Our Ref: BE/100/18/PL
Your Ref:

Town & Country Planning Act 1990 (as amended)
Town and Country Planning (Development Management Procedure) (England) Order 2015
Application for Planning Permission

Development Change of use of ground & first floor office/light industrial unit (B1 - Office & Light Industrial) to gym (D2 - Assembly & Leisure)
Location Unit 8 Clock Park Shripney Road Bersted

PROPOSED GROUND FLOOR PLAN

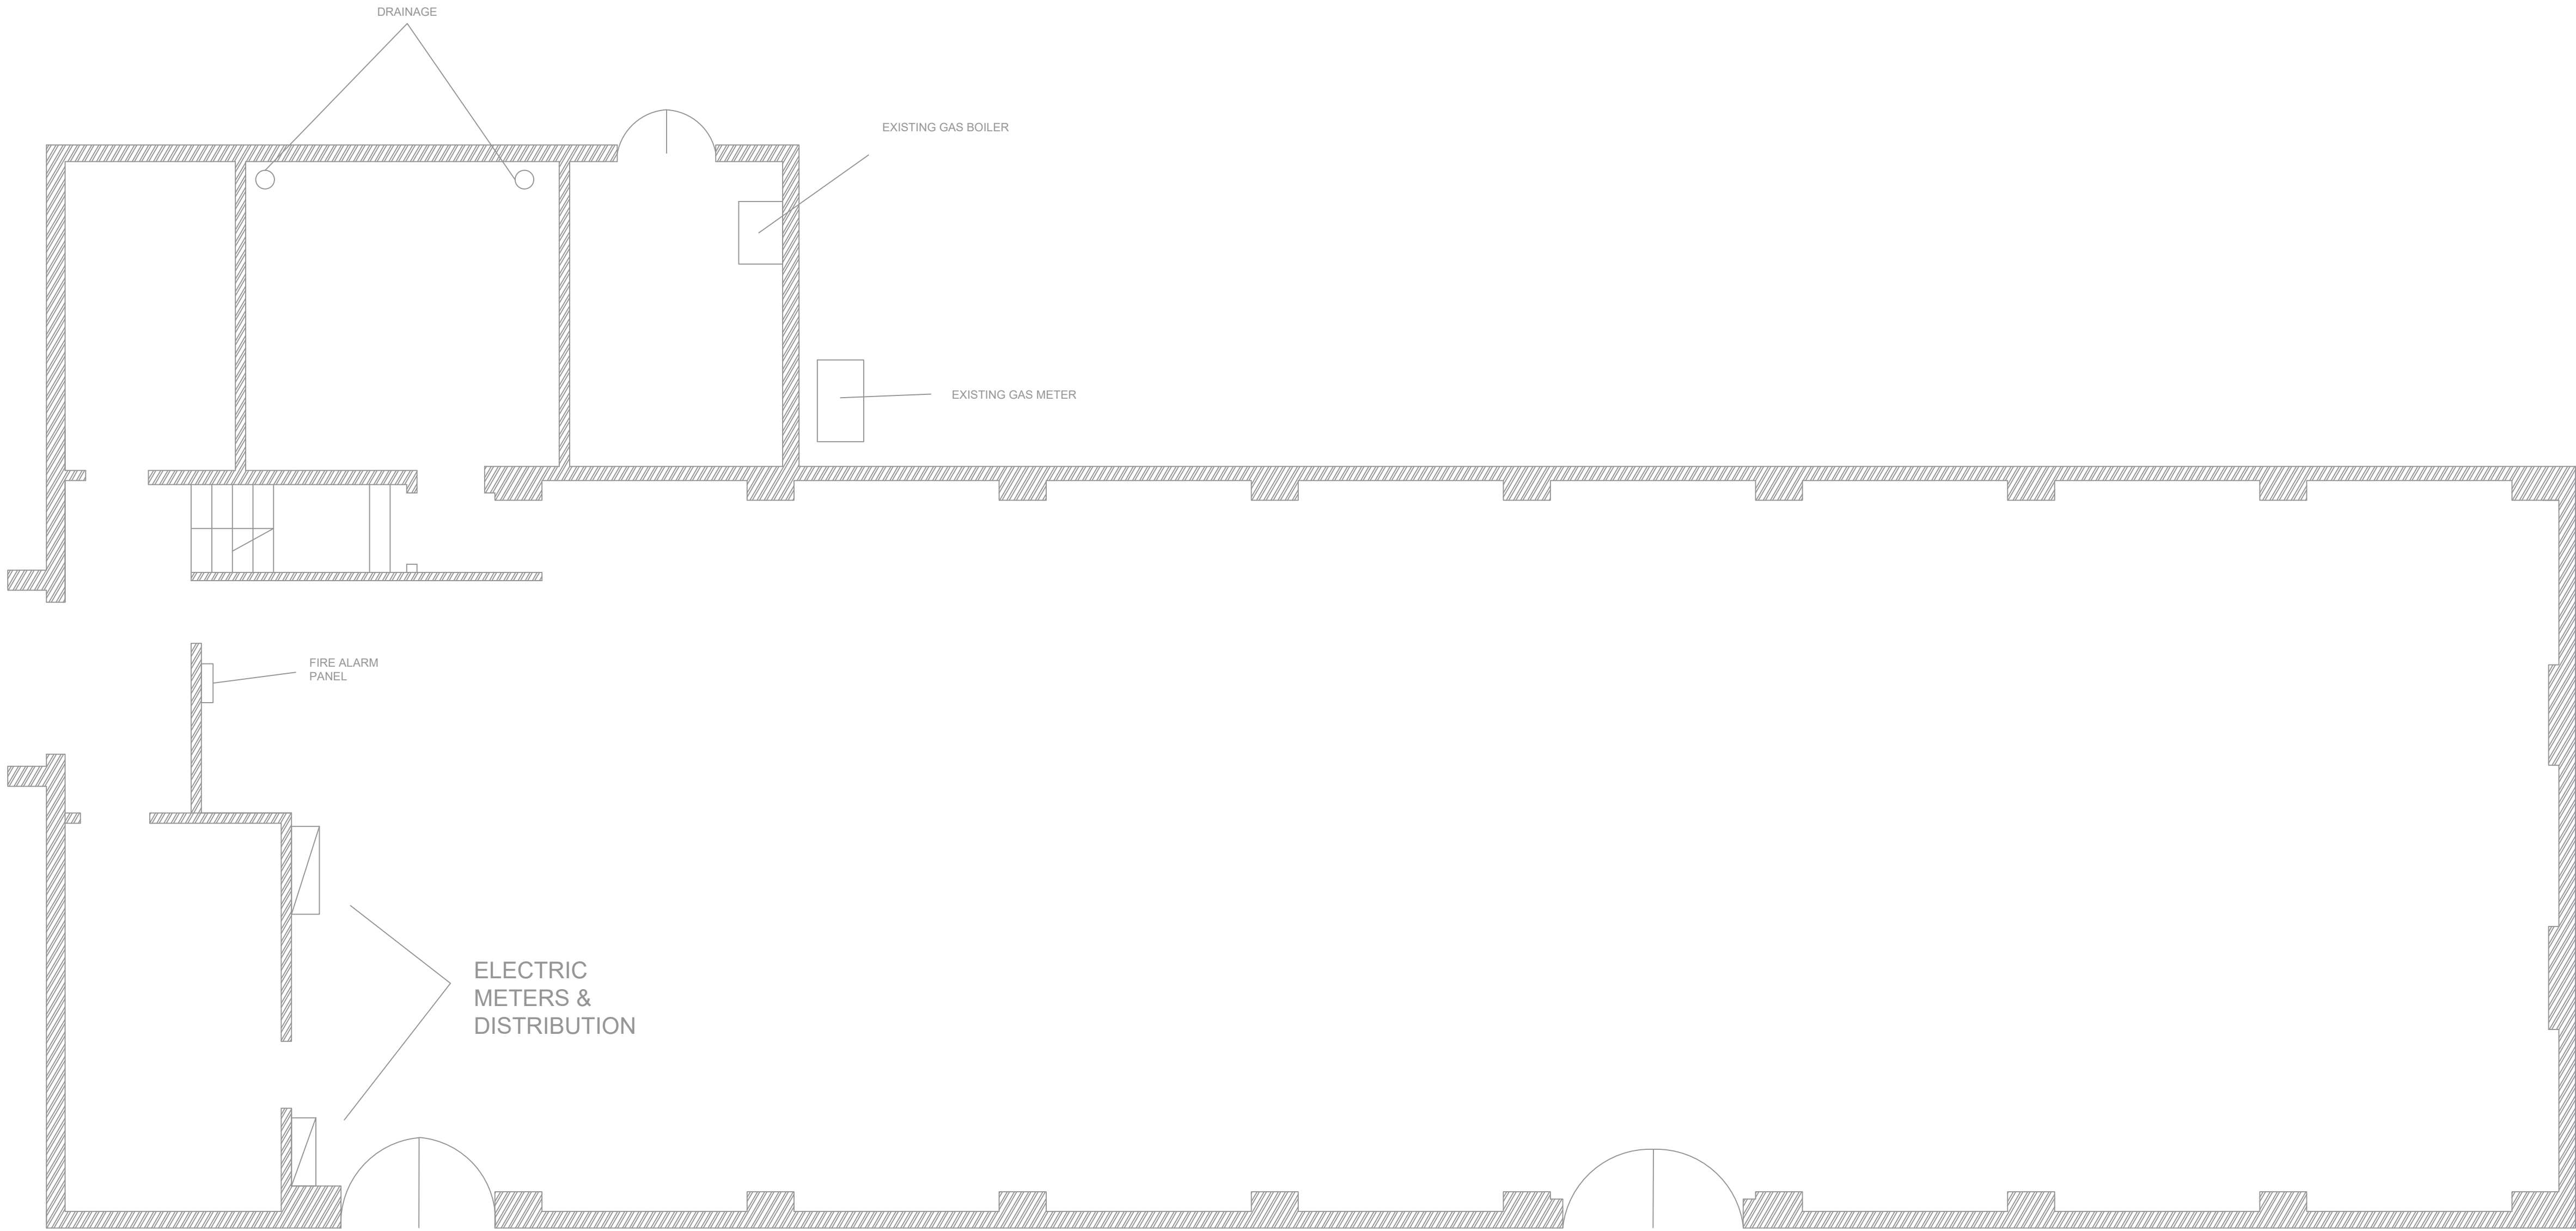
The Proposed Ground Floor plan is not scaling correctly. The wrong sized PDF has been uploaded. Please forward amended plans showing the air conditioning unit
